CITY OF PORTLAND, MAINE

Project Name: 3 Pleasant Avenue Church Redevelopment
Address: 3, 15, and 16 Pleasant Avenue
Applicant: Hardypond Development Company
Planner: Nell Donaldson

Project ID: 2015-102
CBLs: 130-H-13, I-12, and I-14

Pleasant Avenue Church Redevelopment
3, 15, and 16 Pleasant Avenue
Level III Site Plan and Subdivision Review
2015-102
Peninsula Property Development

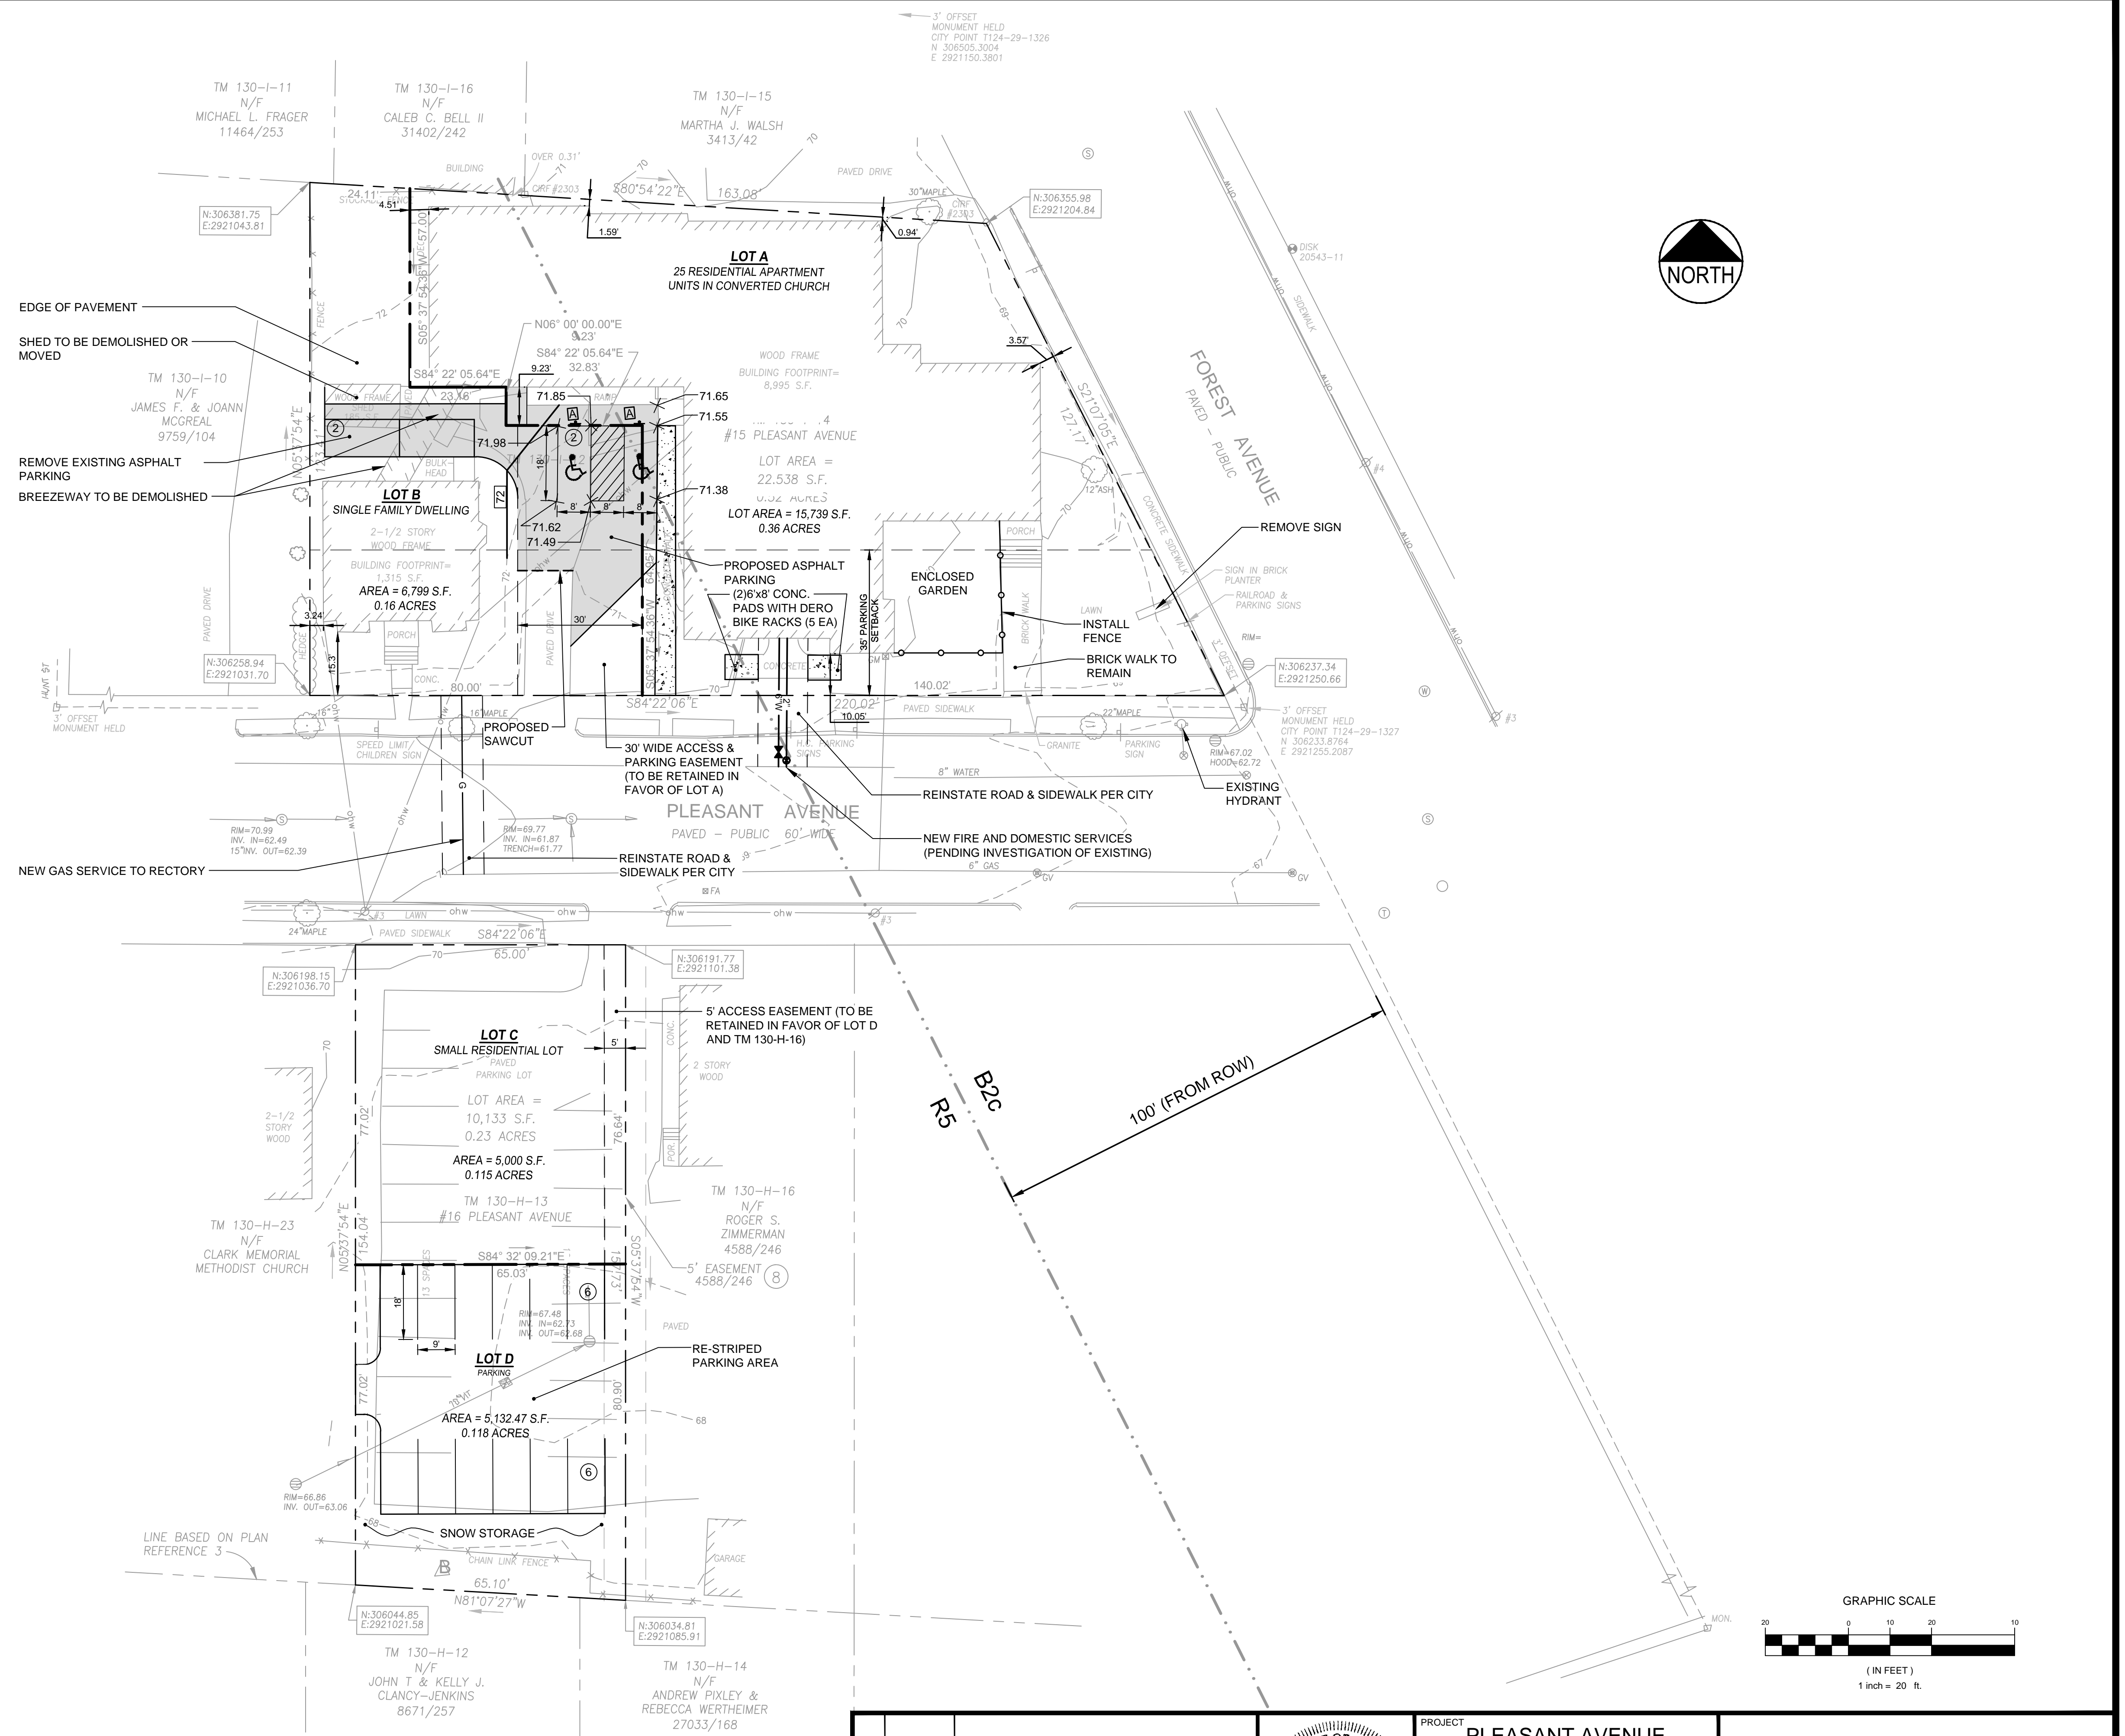
The final plans show a transformer on the Forest Avenue frontage at the northeast corner of the property. Staff has discussed the location of the proposed transformer on the Forest Avenue frontage with DPS, Mr. Tarling, and the applicant in an effort to find a more discreet location. There is some potential that the transformer might be moved to a nearby pole; otherwise, evergreen landscaping or fencing will be required per the site plan ordinance. The resolution of this issue has been included as a condition of approval.

2. The applicant shall resolve the location of the proposed electrical transformer on the Forest Avenue frontage in order to either screen the transformer per the standards of *Section 14-526(b)2b* or otherwise remove it from public view for review and approval by the Planning Authority; and
